El Paso County  
STORMWATER MANAGEMENT PLAN

# Falcon Storage Subdivision

County Project No.: PPR-21-044

Revised  
March 17, 2022

SEDIMENTATION BASINS

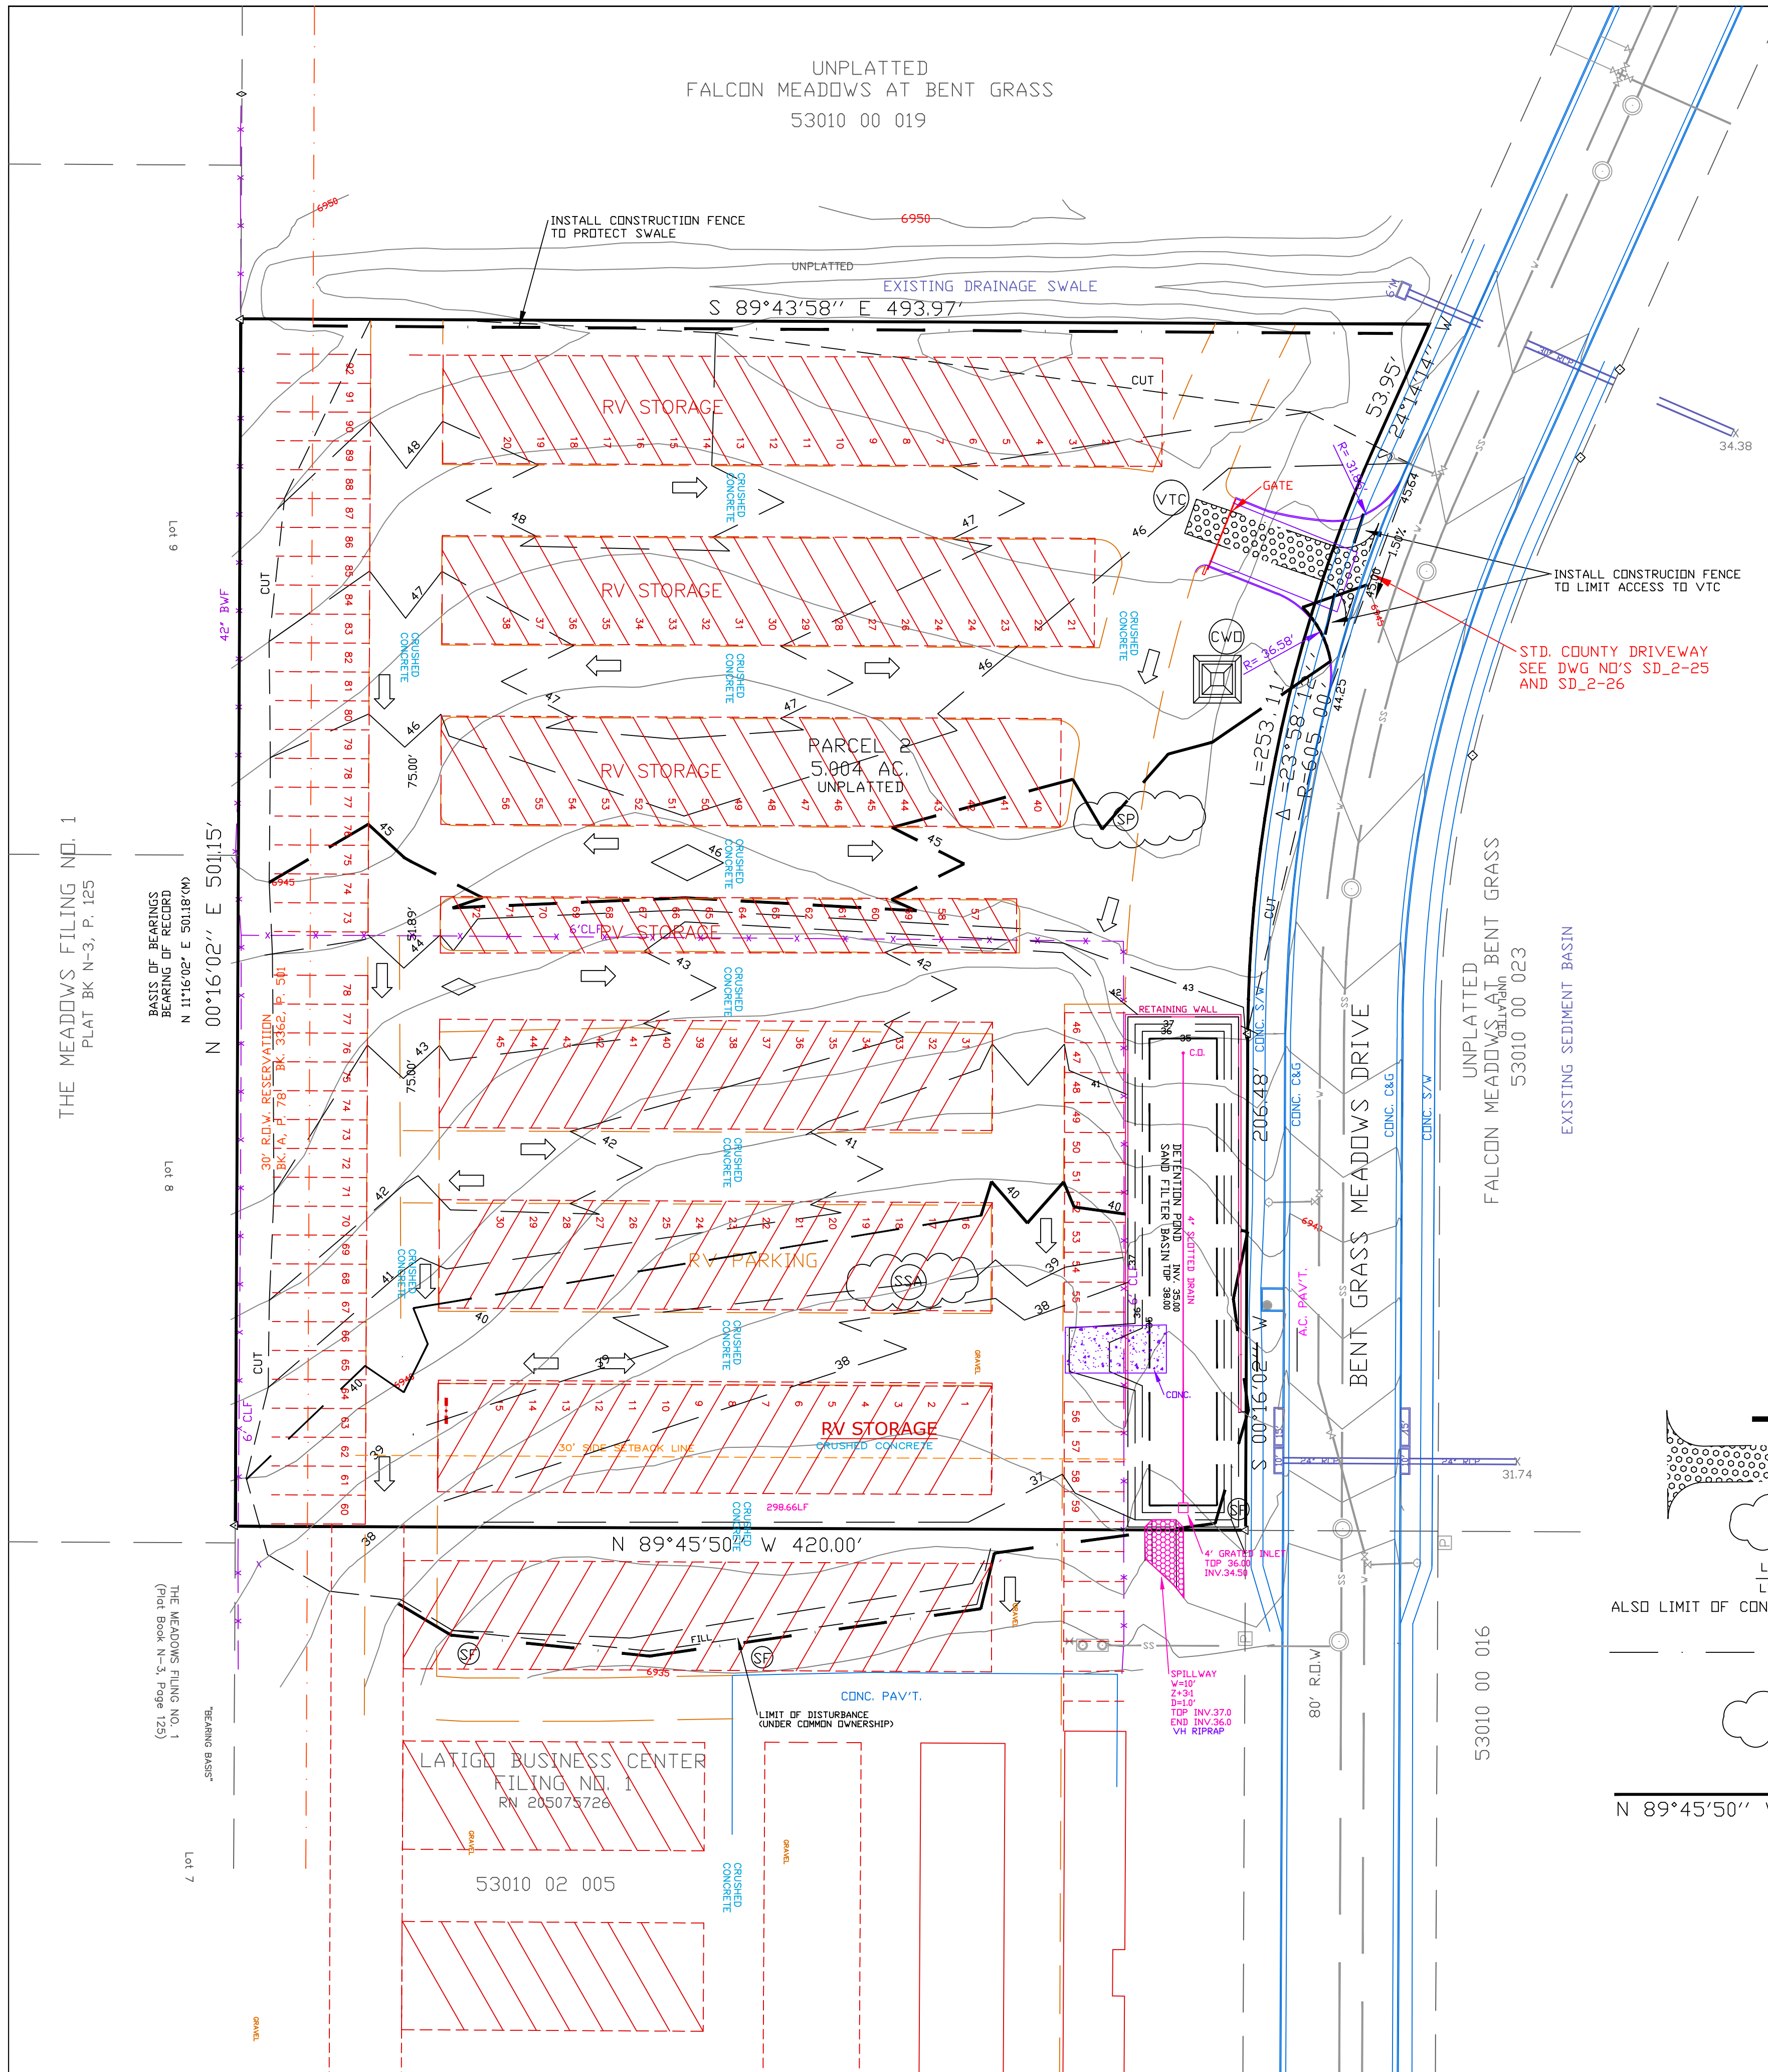
Item#18Discuss temporary sediment basin (TSB)

Item 24. discuss TSB inspection and maintenance
